Your reference: SSD 5346; SSD 5347; SSD 5349
Our reference: ECM 3804935
Contact: Robert Craig
Telephone: (02) 4732 7593

State Significant Development Applications for Stages 2B and Stage 2C (SSD-5346), Stage 2D (SSD-5347) and Stage 3B (SSD-5349) of the North Penrith Mixed-Use Development.

Attachment 1

NORTH PENRITH
STAGE 2B & 2C
WATER FEATURE
SECTIONS

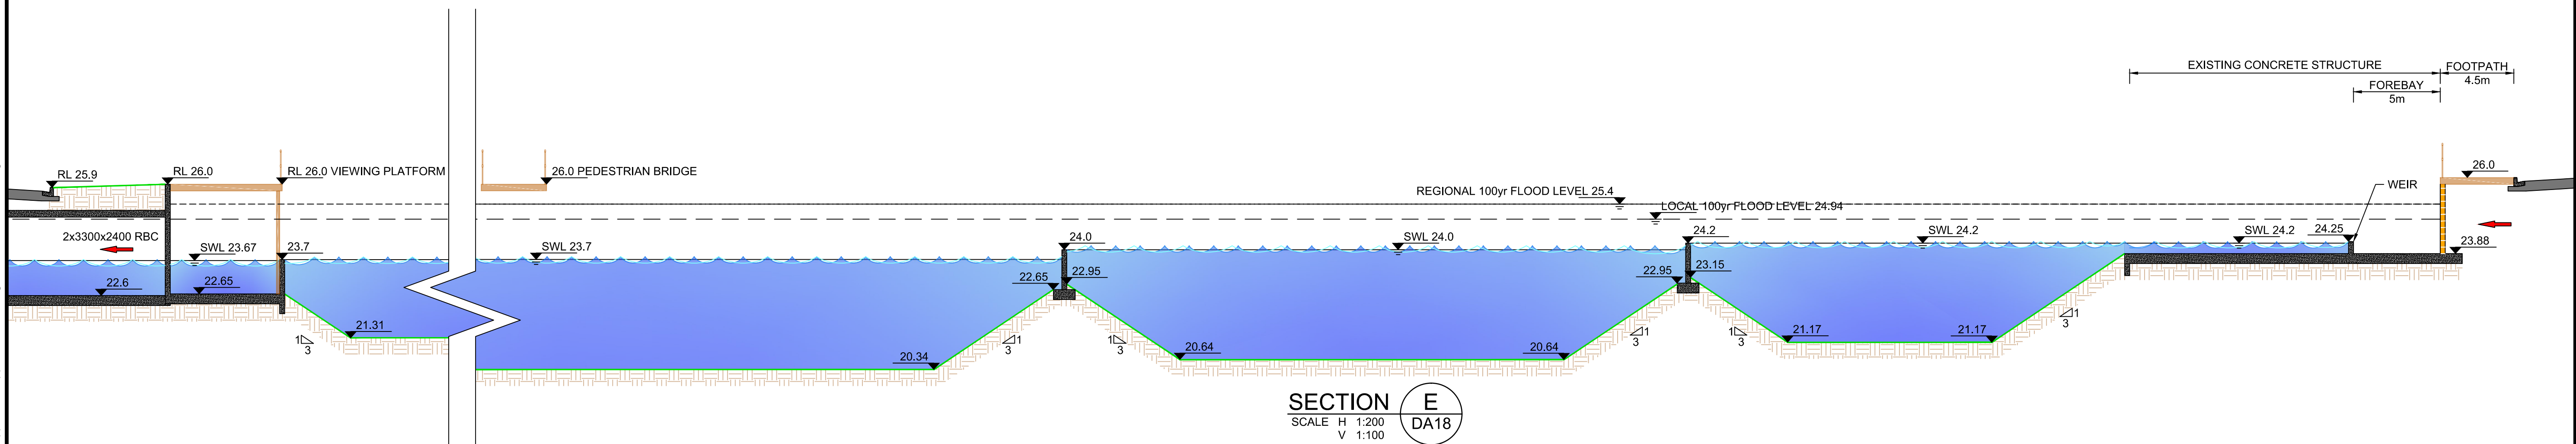
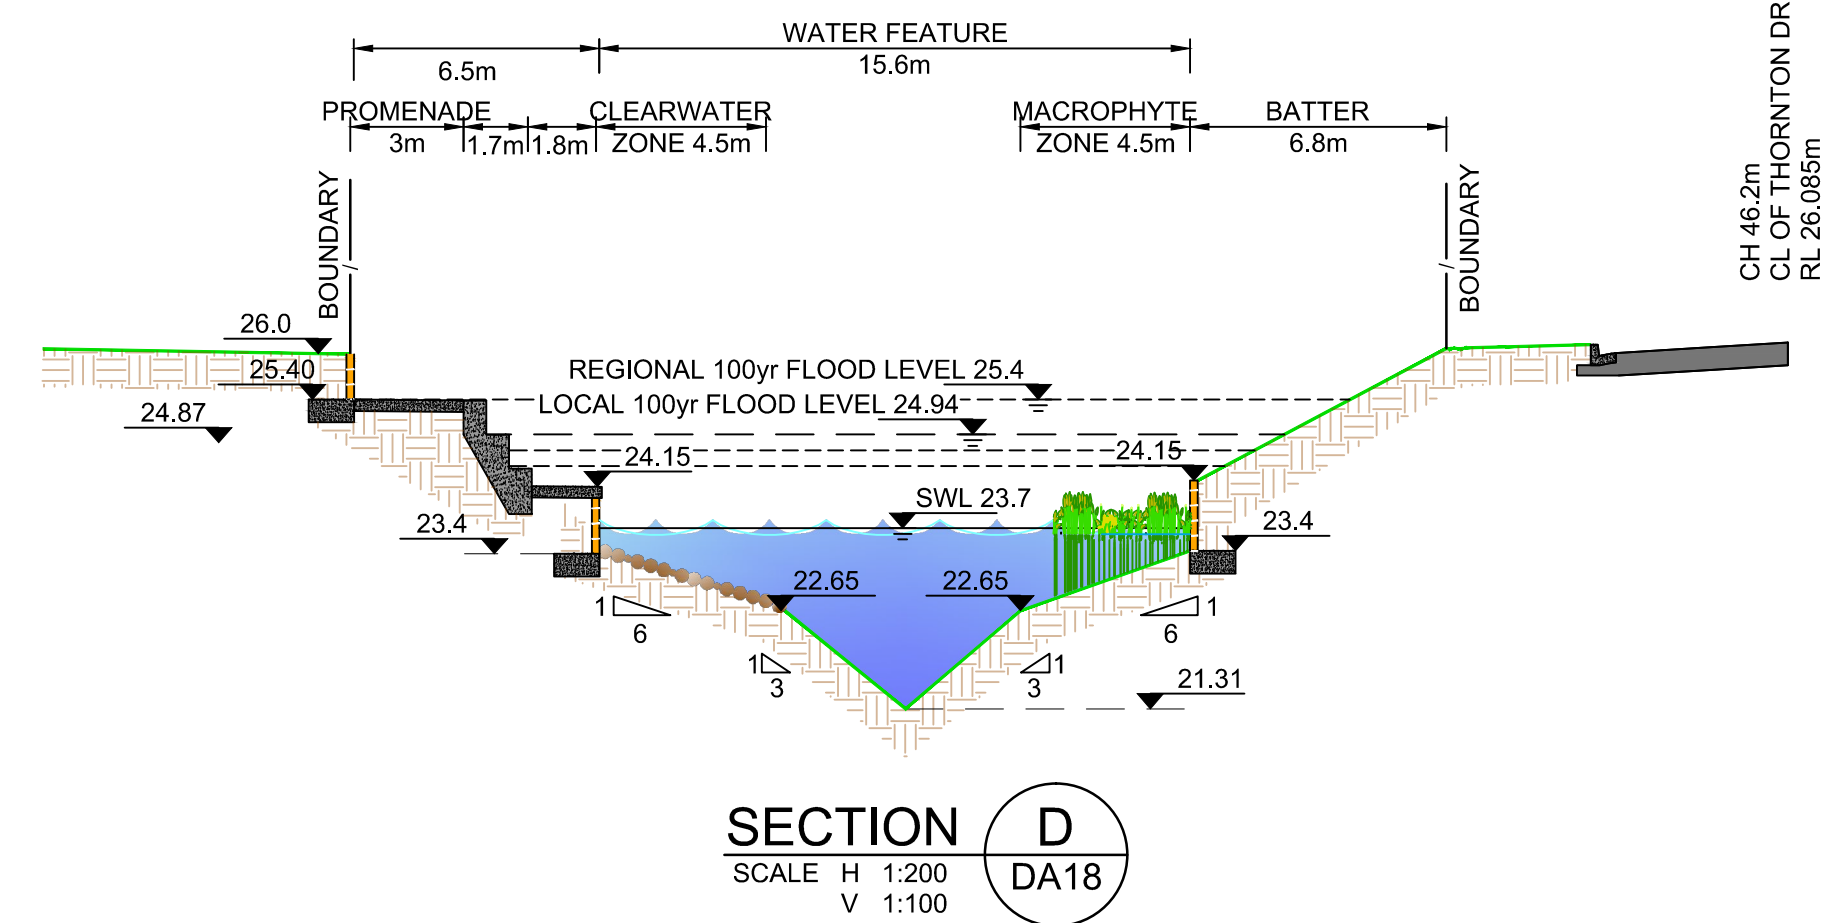
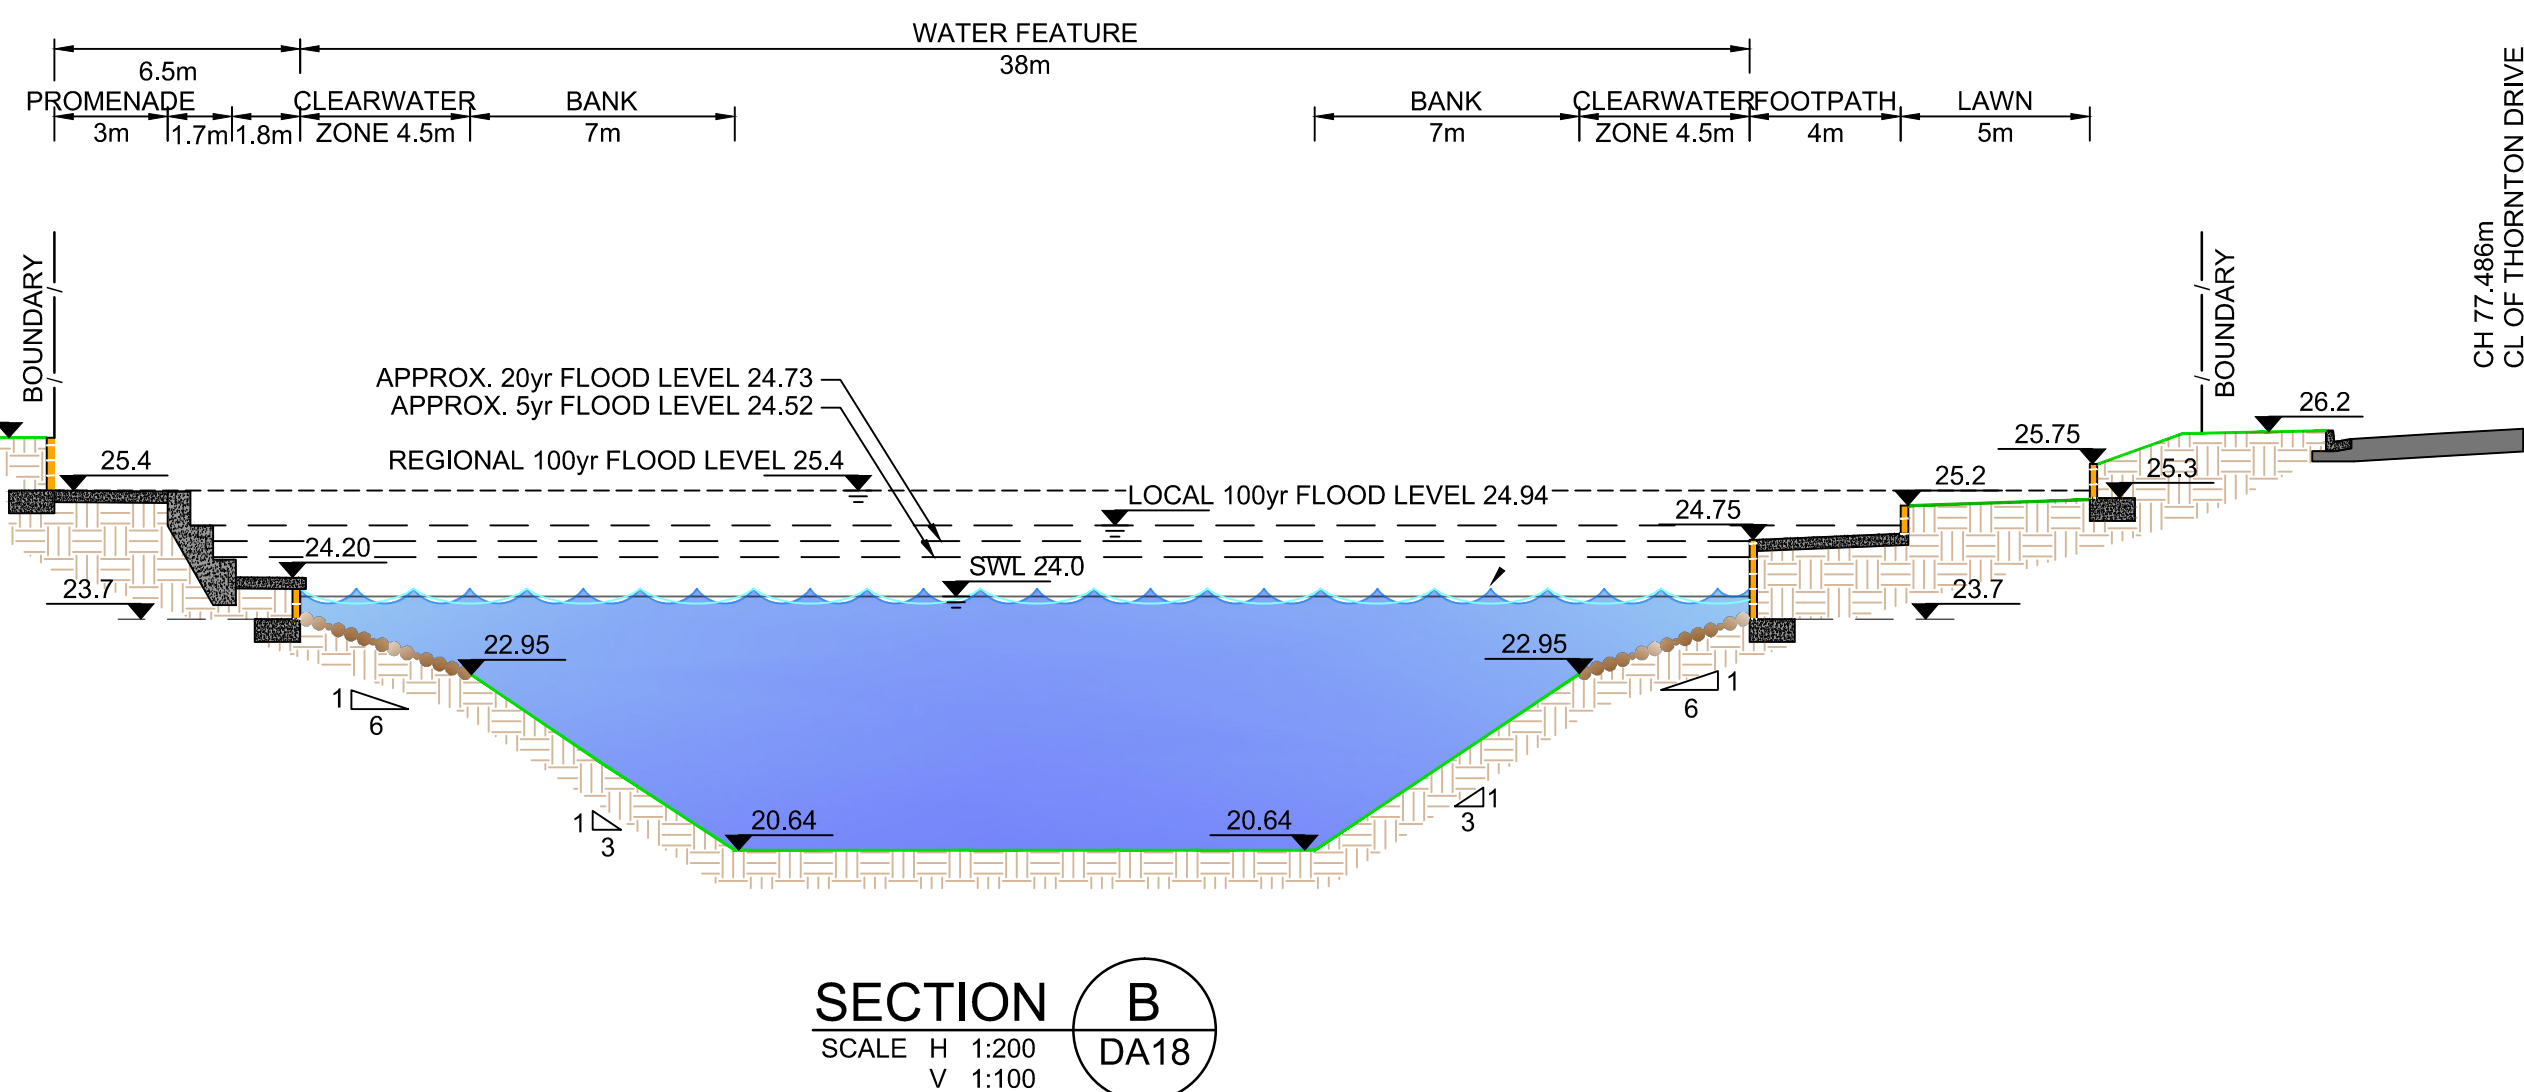
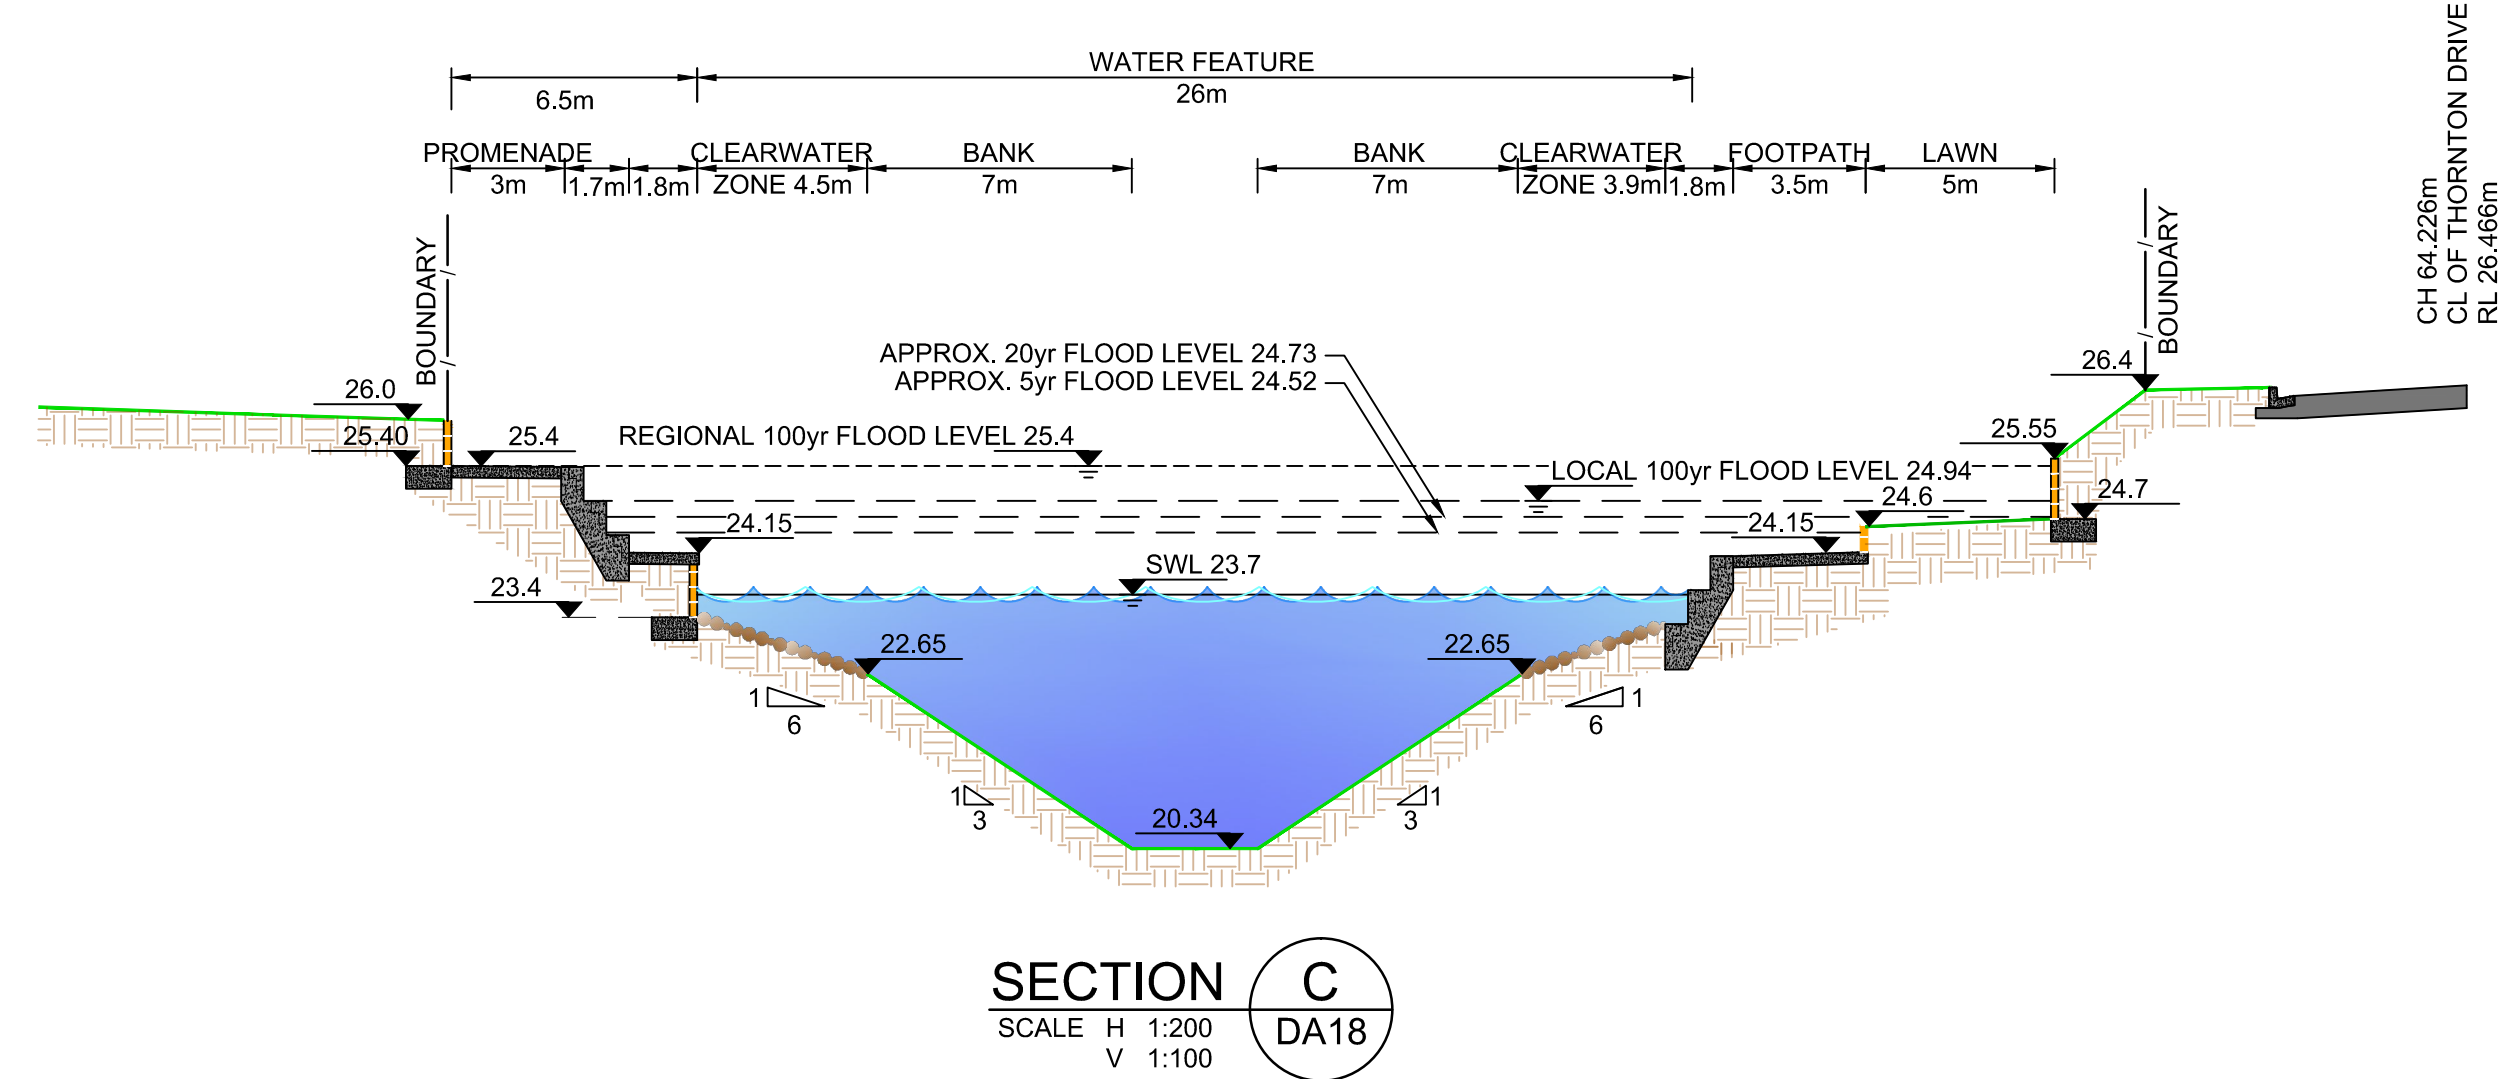
- The proposed channel is designed to provide a stormwater detention and a treatment function as well as provide some aesthetic value for the site. It is considered that the channel will have limited water quality benefits due to its design and lack of vegetation.

- There is likely to be an issue with sedimentation of the channel which will ultimately result in long term management issues with regards to algae growth. Detention ponds such as the one proposed are commonly associated with algae management and unwanted vegetation management issues. The proposed water reticulation system and reliability of aerators will be critical to the effective management of the canal and failure would likely result in management issues.

- The channel is also likely to act as a sediment basin. As such, it will be essential that adequate access be provided for maintenance and to remove sediment and other materials. Consideration for removing floating litter and other waste material should also be made during the detailed design stage and factored into the final construction of the channel.

- A detailed operational and management manual for the operation of the pumps, aerators, reticulation systems and management of the canal should be submitted to Council for approval before the handover of the assets.

<p>Public Health Matters</p>	<ul style="list-style-type: none"> ● Given the proposed recreational areas, there is the potential for temporary events involving the sale of food to be carried out. A condition in relation to temporary food stalls and mobile food vendors should therefore be imposed (see below). ● It is noted that water drinking fountains are proposed for the site. A condition should therefore be imposed to ensure that the water from these fountains is potable and the fountains are maintained in good working order and in a clean condition (see below). ● It is also noted that there will be aeration devices as part of the water feature. The applicant should consider the

<p>potential for legionella dispersal in aerosols in the construction and operation of these devices.</p> <ul style="list-style-type: none"> • Recommended conditions include the following: <ul style="list-style-type: none"> ○ The construction and operation of any temporary food outlet or mobile food vending vehicles shall be carried out in accordance with the requirements of the Food Act 2003, Food Regulation 2010, Food Safety Standards under the Australian and New Zealand Food Standards Code and the current guidelines for temporary events produced by the NSW Food Authority. Operators of temporary food outlets and mobile food vending vehicles must complete and return Penrith City Council's "Application to Sell Food" form at least 14 days prior to operating. Solid and liquid waste storage and disposal must be carried out in accordance with the Food Act 2003, Local Government Act 1993 and Protection of the Environment Operations Act 1997. ○ Drinking water fountains must be supplied with potable water in accordance with the current Australian Drinking Water Guidelines. The fountain and associated equipment must be maintained in good working order and cleaned as part of a regular cleaning schedule. ○ The water feature shall be designed and maintained to prevent the proliferation and dispersal of legionella bacteria. The aeration devices shall be designed to produce coarse water droplets to minimise aerosol formation and prevent the dispersal of legionella bacteria. The operation and maintenance plan shall include strategies for the control of legionella proliferation and dispersal.
